Photographic Report

Embedded Photo	
Client Name	United Living
Name of Surveyor	Richard Keeley
Project Name	Mulready House
Address	Mulready House, Marsham St, London SW1P 4JL
Phone Number	079-401-2929
Email Address	Richard@opuswaterproofing.co.uk
Weather Conditions	Overcast

02761-UL-MUL-CON-DWG-A-103 PL1

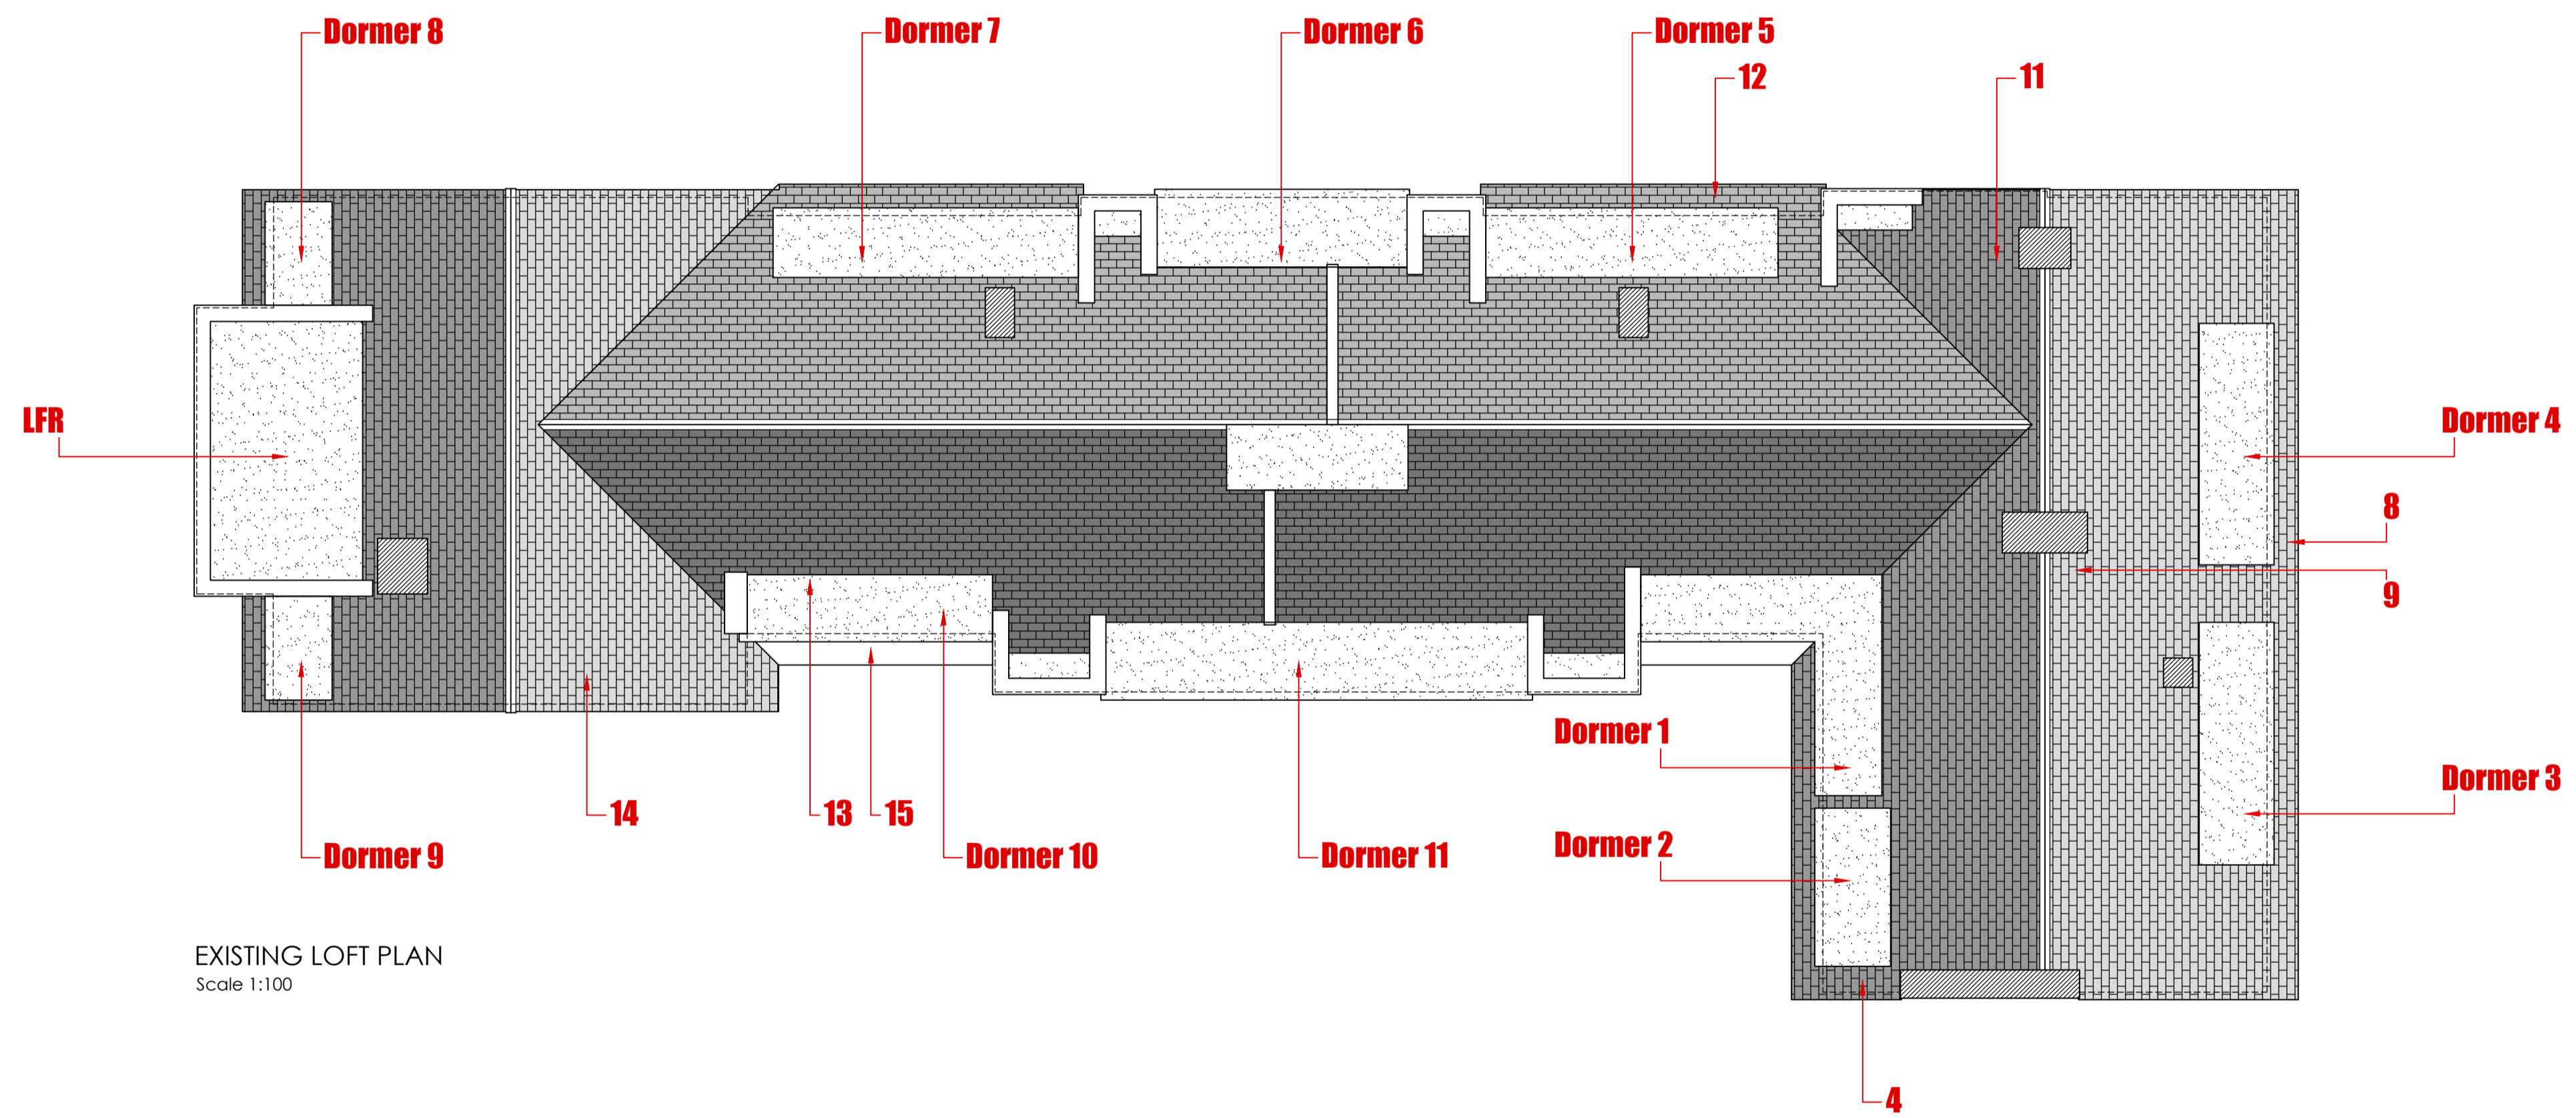
Comments	<p>The existing Lead has been repaired in multiple locations which would suggests there has been historic water ingress. There was also evidence of mastic repairs to the gussets and flashings.</p>
Proposed Works	<p>If water is found to be penetrating the building. We would recommend changing the lead on a like for like basis to the areas identified within the pictures. All lead works would be carried out in line with the current LSA guidelines. We would also recommend lining the existing aluminum gutters with a liquid applied waterproofing.</p>
Quantity of Materials	<p>10 roof bays 1200mm x 2000mm (code 6 lead sheet) - 1lm 100mm flashing (code 5lead) - 1 no lead gusset (code 6 lead) - liquid seal 9lm</p>

Comments	<p>The existing Lead has been repaired in multiple locations which would suggest there has been historic water ingress. There was also evidence of mastic repairs to the Lead gussets and flashings. It was also noted the timber soffit Beneath the gutter is rotting in multiple locations which would suggest the existing guttering is leaking.</p>
Proposed Works	<p>We would recommend changing the lead on a like for like basis to the areas identified within the pictures. All lead works would be carried out in line with the current LSA guidelines. We would also recommend lining the existing aluminum gutters with a liquid applied waterproofing</p>
Quantity of Materials	<p>LHS & RHS Lead cheek 4m2 each (code 6 lead sheet) - 3 lm lead flashing (code 5 lead sheet) - 2 no. Lead gusset (code 5 lead sheet) liquid seal 6 lm</p>

Comments	The lead cheeks are showing signs of recent replacement with a poor level of workmanship. The flashings beneath the windowsill have been insufficiently fixed and will require replacement as they are no longer fit for purpose. It was also noted the timber soffit Beneath the gutter is rotting in multiple locations which would suggest the existing guttering is leaking or getting behind the timber at the drainage point.
Proposed Works	We would recommend changing or repairing the lead on a like for like basis to the areas identified within the pictures. All lead works would be carried out in line with the current LSA guidelines. We would also recommend lining the existing aluminum gutters with a liquid applied waterproofing. New Timber soffits would be recommended or repair where possible.
Quantity of Materials	LHS & RHS cheeks redress existing. 5 lm lead flashing (code 5) 2 no lead gusset (code 5) liquid seal 9lm

Comments	The lead cheeks are showing signs of recent replacement with a poor level of workmanship. The flashings beneath the windowsill have been insufficiently fixed and will require replacement as they are no longer fit for purpose. It was also noted the timber soffit Beneath the gutter are rotting in multiple locations which would suggest the existing guttering is leaking or getting behind the timber at the drainage point.
Proposed Works	We would recommend changing the lead on a like for like basis to the areas identified within the pictures. All lead works will be carried out in line with the current LSA guidelines. We would also recommend lining the existing aluminum gutters with a liquid applied waterproofing
Quantity of Materials	LHS Lead cheek 4m ² each (code 6 lead sheet) 5 lm lead flashing (code 5 lead sheet) 2 no. Lead gusset (code 5 lead sheet) liquid seal 9lm

Comments	The existing Lead roof has been repaired in multiple locations which would suggests there has been historic water ingress. The flashing beneath the window seal has become loose and requires re-fixing. The gutters where also blocked and showing signs of leakage.
Proposed Works	If water is found to be penetrating the building. We would recommend changing the lead on a like for like basis to the areas identified within the pictures. All lead works would be carried out in line with the current LSA guidelines. We would also recommend lining the existing aluminum gutters with a liquid applied waterproofing.
Quantity of Materials	10 no. Lead bays (Code 6 Lead) 3 lm flashing (Code 4 Lead) 6lm Liquid seal

Comments	The existing Lead roof has been repaired in multiple locations, mastic repairs where present in the bays. The lead cheeks are showing signs of recent replacement with a poor level of workmanship The gutters are blocked and showing signs of leakage.
Proposed Works	We would recommend changing the lead on a like for like basis to the areas identified within the pictures. All lead works would be carried out in line with the current LSA guidelines. We would also recommend relining the existing aluminum gutters with a liquid applied waterproofing.
Quantity of Materials	6 no. Lead bays (Code 6 Lead) 3 lm flashing (Code 4 Lead) 6lm Liqui seal

Comments	<p>The existing Lead roof has been repaired in multiple locations, mastic repairs were present in the bays. The lead cheeks are showing signs of recent replacement with a poor level of workmanship, holes were also found within the lead sheet and flashing are coming away from the wall. The gutters are blocked and showing signs of leakage.</p>
Proposed Works	<p>We would recommend changing the lead on a like for like basis to the areas identified within the pictures. All lead works would be carried out in line with the current LSA guidelines. We would also recommend relining the existing aluminum gutters with a liquid applied waterproofing.</p>
Quantity of Materials	<p>7 no. Lead bays (Code 6 Lead) 3 lm flashing (Code 4 Lead) 6lm Liquid seal</p>

Comments	The decorative soffits were showing sign of rot mainly due to the existing gutters leaking. Also, it was noted there has been previous repairs to the timber work installed to a poor standard.
Proposed Works	We would recommend relining the gutter with a Liqui Seal Coating and the timber works being replaced by a skilled carpenter.
Quantity of Materials	4 lm liquid seal

Comments	<p>The existing pointing is missing and not providing any termination the Lead Flashing. Also, the Gussets have been installed to a poor standard.</p>
Proposed Works	<p>We would recommend changing the lead on a like for like basis to the areas identified within the pictures. All lead works would be carried out in line with the current LSA guidelines. Repointing the flashing where necessary. We would also recommend relining the existing aluminum gutters with a liquid applied waterproofing.</p>
Quantity of Materials	<p>1lm of pointing 1 no. gusset</p>

Comments	The existing Lead has been repaired in multiple locations which would suggests there has been historic water ingress. The was also evidence of mastic repairs to the gussets and flashings.
Proposed Works	If water is found to be penetrating the building. We would recommend changing the lead on a like for like basis to the areas identified within the pictures. All lead works would be carried out in line with the current LSA guidelines. We would also recommend lining the existing aluminum gutters with a liquid applied waterproofing.
Quantity of Materials	6 roof bays 1200mm x 2000mm (code 6 lead sheet) - 4lm 100mm flashing (code 5 lead) - liquid seal 9lm

<p>Photos</p>	
<p>Comments</p>	<p>This image shows Verge movement and enlarge bonds between the tiles.</p>
<p>Proposed Works</p>	<p>The tiles would require relining the ensure the bonds are equal without removing the cemented verge.</p>
<p>Quantity of Materials</p>

Comments	Images show broken and slipped tiles
Proposed Works	We would recommend changing the tiles where necessary on a like for like basis.
Quantity of Materials

<p>Photos</p>	
<p>Comments</p>	<p>Images shows missing tiles around Soil Stack.</p>
<p>Proposed Works</p>	<p>New tiles are required on a like for like basis.</p>
<p>Quantity of Materials</p>	<p>10no. tiles</p>

<p>Photos</p>	
<p>Comments</p>	<p>Image shows Broken and defective tiles</p>
<p>Proposed Works</p>	<p>New tiles are required on a like for like basis.</p>
<p>Quantity of Materials</p>	<p>3no. tiles required</p>

Comments	<p>The existing Lead has been repaired in multiple locations which would suggest there has been historic water ingress. The eaves course has also dropped in various locations.</p>
Proposed Works	<p>We would recommend changing the lead on a like for like basis to the areas identified within the pictures. All lead works would be carried out in line with the current LSA guidelines. We would also strip back the bottom three course and investigate the reason why the tiles have dropped and repair and replace accordingly.</p>
Quantity of Materials	<p>Lead Bays 14 no. – Lead gutter 71m – Eve's course 71m</p>

Photos	
Comments	Images shows the eaves course has also dropped in various locations.
Proposed Works	We would also strip back the bottom three course and investigate the reason why the tiles have dropped and repair and replace accordingly
Quantity of Materials	Eve's course – 5lm

<p>Photos</p>	
<p>Comments</p>	<p>Image show a slipped Tiles</p>
<p>Proposed Works</p>	<p>New tiles are required on a like for like basis.</p>
<p>Quantity of Materials</p>	<p>3no. tiles required</p>

<p>Photos</p>	
<p>Comments</p>	<p>Images shows a slipped Tiles and slipped Lead flashings</p>
<p>Proposed Works</p>	<p>The existing Lead flashing would need to be rescued in line with the current LSA Guidelines and the tiles replaced on a like for like basis.</p>
<p>Quantity of Materials</p>	<p>4lm Lead Flashing – 10no. Tiles</p>
